DELEGATED HOUSEHOLDER DECISION

Item No.	Report of the Head of Planning, Sport and Green Spaces	
Address	16 BLACKLANDS DRIVE HAYES	
Development:	First floor side extension, conversion of existing garage to habitable room, single storey rear extension and detached garage involving demolition of existing rear extension	
LBH Ref Nos:	9067/APP/2016/1141	
Drawing Nos:	Location Plan (1:1250) CD-BAI-2015-001 CD-BAI-2015-002(B) CD-BAI-2015-003(B) CD-BAI-2015-004(B) CD-BAI-2015-005(B) CD-BAI-2015-006	
Date Plans Received:	21/03/2016	Date(s) of Amendment(s):
Date Application Valid:	05/04/2016

Date: 28th July 2015 Scale: As specified Drg No. CD-BAI-2015-004(B)

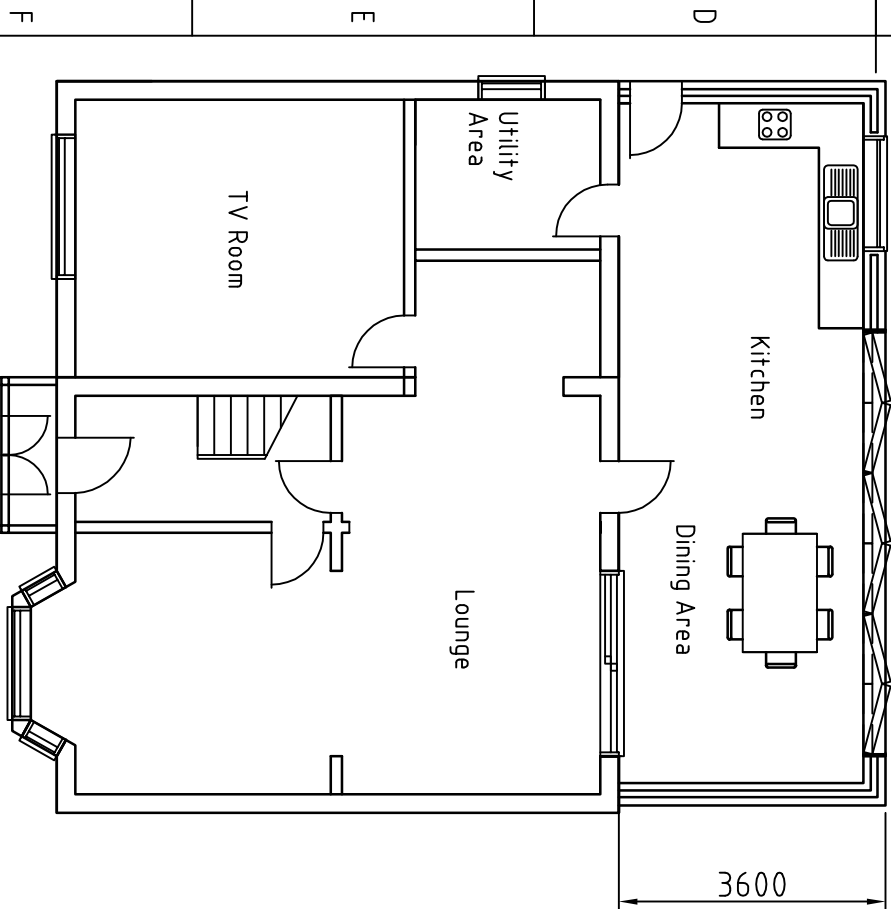
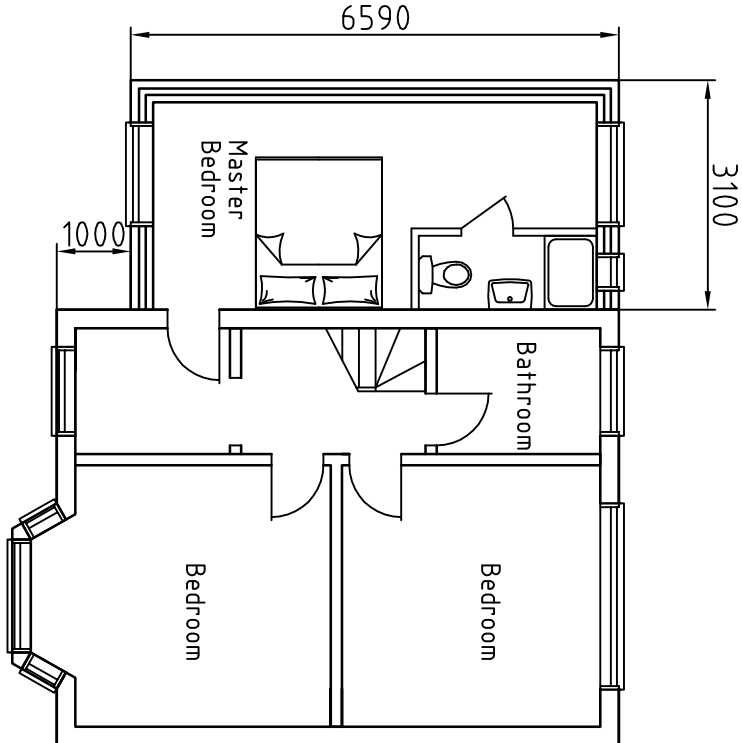
The proposed first floor side extension would be set back from the western side boundary with Meadow View Road by 1.1m, which complies with the guidance in paragraph 5.1 of the Council's adopted HDAS SPD: Residential Extensions (December 2008). This guidance requires a minimum set-in of 1m for first floor/two storey side extensions from side boundaries. The existing attached side garage is set-in more than 1m from the side boundary, so there is no requirement for an additional set-in of the first floor side extension according to the guidance in paragraph 5.1 of the HDAS SPD. However, the corner plot location of the site is noted, and even though the existing garage is built close to the side boundary, it maintains considerable upper level open space. The upper level open space is complemented by the trees and shrubbery along that boundary and provides some visual relief in what is a densely developed area. Even though it is noted that a number of junction properties in the area have been built up close to their side boundaries including the adjacent dwelling on the opposite corner, No. 18 Blacklands Drive, the considerable open space to side boundaries is a feature of several junction properties in the surrounding area. It is considered that the 1.1m set-in of the proposed first floor side extension from the side boundary is such that it would virtually infill this upper level open space and visual gap, particularly at the front of the site, and it would result in the loss of this prominent feature of the street scene to the detriment of the visual amenity of the streetscene and the wider area. It is also considered that the set-in of 1.1m from the side boundary is such that the first floor side extension would result in post-development pressures and impact on the trees along the boundary. It is instructive to note that works to build up the adjacent dwelling at No.18 close to its side boundary took place well before the adoption of the current local plan, and it is considered that the building up of the proposed first floor side extension so close to the side boundary would exacerbate the impact already resulting from the extended dwelling at No.18 on the visual amenities of the streetscene and surrounding area. Furthermore, the 1.1m set-in of the proposed first floor side extension from the side boundary is such that it would significantly extend beyond the return front building line of adjacent dwellings on Meadow View Road (No. 2 Meadow View Road being the closest).

The proposed first floor side extension would be 7.6m deep, 4m wide and it would line up with the front wall of the dwelling. The lining up with the front wall is contrary to the guidance in paragraph 5.6 of the HDAS SPD, which requires first floor/two storey side extensions to be set back 1m from the main front building line of a semi-detached dwelling. Furthermore, the matching hipped roof of the first floor side extension would be equal to the height of the existing main roof, which is contrary to the guidance in

paragraph 5.8 of the HDAS SPD. That guidance specifies that the roof height of side extensions at semi-detached dwellings should be lowered by at least 0.5m from the main roof line. The original width of the dwelling is 6m, and the proposed 4m width of the proposed side extension would comply with paragraph 5.10 of the HDAS SPD, which specifies that the width of a side extension should be between half and two thirds of the main house depending on the plot size and character of the area. Notwithstanding the fact that there is no objection to the proposed conversion of the side garage to a habitable room in and of itself, it is considered that the first floor side extension would not integrate well visually with the host dwelling, and would not constitute a subordinate and proportionate addition to the dwelling. As such, the first floor side extension would appear incongruous and dominating in relation to the host existing dwelling, neighbouring properties and the streetscene.

The proposed first floor side extension, by virtue of its siting, scale, bulk, width and design including the lack of a set back from the front building line of the existing dwelling and lack of a set down of the ridge from the main ridge of the roof, would fail to appear as a subordinate addition and would thus be detrimental to the appearance of the original dwellinghouse, the character, appearance and symmetry of the pair of semi-detached dwellings of which it forms a part and the visual amenities of the street scene and the wider area. The proposal is therefore contrary to Policy BE1 of the Hillingdon Local Plan: Part One - Strategic Policies (November 2012), Policies BE13, BE15 and BE19 of the Hillingdon Local Plan: Part Two - Saved UDP Policies (November 2012) and the adopted Supplementary Planning Document (SPD) HDAS: Residential Extensions.

The proposed first floor side extension, by reason of its close proximity to the western side boundary and siting in this open prominent corner position, would result in the loss of vegetation along that boundary and an important gap characteristic to the area, resulting in a cramped appearance. The proposal would therefore represent an over-development of the site to the detriment of the character and the visual amenities of the area and to this existing open area of the street scene. Therefore the proposal is contrary to Policy BE1 of the Hillingdon Local Plan: Part One - Strategic Policies (November 2012), Policies BE13, BE15 and BE19 of the Hillingdon Local Plan: Part Two - Saved UDP Policies (November 2012) and the adopted Supplementary Planning Document (SPD) HDAS: Residential Extensions.

Date: 28th July 2015	Scale: As specified	Drg No. CD-BAI-2015-002(B)
----------------------	---------------------	----------------------------

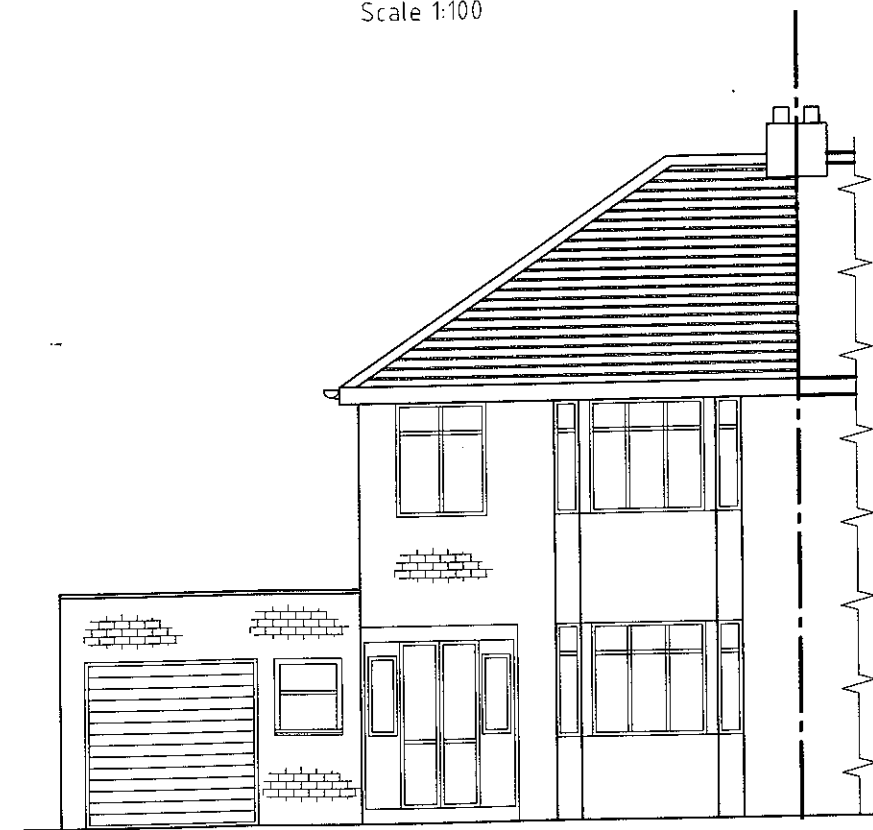
The proposed single storey rear extension would be 3.6m deep along the shared boundary with No.14, 9.8m wide and 3.8m high with a pitch roof. Whilst the depth of the proposed rear extension complies with the related guidance in paragraph 3.3 of the HDAS SPD, the height exceeds the 3.4m maximum required for a pitch roof for a rear extension, as specified in paragraph 3.7 of the HDAS SPD. However, the attached dwelling to the east at No. 14 Blacklands Drive has an existing 3.1m deep single storey rear extension with a flat roof height of 3.2m. The degree of the sloping pitch of the proposed rear extension relative to the flat roof height of the extension at attached No.14 is such that it would not constitute an unduly bulky and/or overbearing addition to the application dwelling. As such, it is considered that the proposed single storey rear extension, in and of itself, would constitute an acceptable proportionate addition.

Drg No. CD-BAI-2015-006

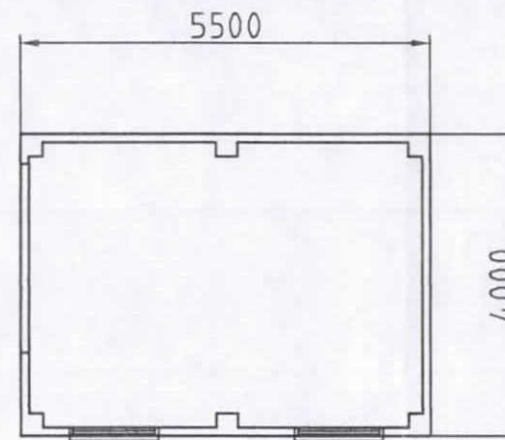
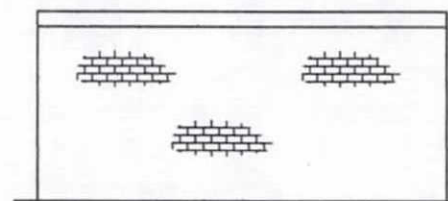
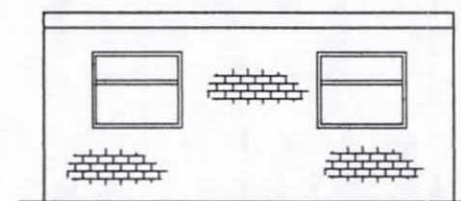
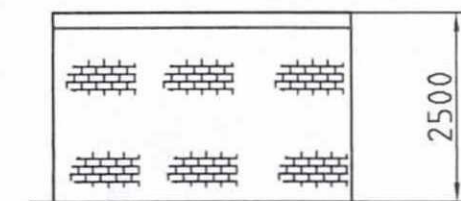
With regards to the siting of the proposed detached garage in the rear garden, even though it would not be accessed from a rear service road as specified in paragraph 9.5 of the HDAS SPD, it would be accessed from an existing vehicular crossover off the Meadow View Road highway. As such, there is no material objection to its proposed siting in the rear garden. The proposed garage would be set-in from the back edge of the highway by 5m, which exceeds the minimum required of 2.4m in paragraph 9.5 of the HDAS SPD. The garage would have a roller shutter and its internal dimensions would exceed the required minimum of 4.8m width and 3m depth as specified in paragraph 9.5 of the HDAS SPD. The proposed height of 2.5m is similar to the maximum height permitted for outbuildings in residential curtilages by Class E, Part 1, Schedule 2 of the Town and Country Planning (General Permitted Development) (England) Order 2015. As such, it is considered that the proposed garage would constitute an acceptable proportionate addition in the curtilage of the existing dwelling.

off from views at the closest adjacent property at No. 2 Meadow View road by an intervening attached garage at the side of that neighbouring property. It is therefore considered that the proposal would not harm the residential amenities of the occupiers of the adjoining neighbours in terms of increased overshadowing, loss of sunlight, loss of outlook and visual intrusion. As such, the proposal is in compliance with Policies BE20, BE21 and BE24 of the Hillingdon Local Plan: Part Two - Saved UDP Policies (November 2012).

Although the existing attached side garage would be lost as a potential off-street parking facility, the loss would be offset by the proposed detached garage in the rear garden and the existing front garden parking area, which is capable of accommodating at least two cars parked safely at right angle to the highway. Therefore there would be no conflict with Policy AM14 of the Hillingdon Local Plan: Part Two - Saved UDP Policies (November 2012) in respect of the provision of adequate off-street car parking.
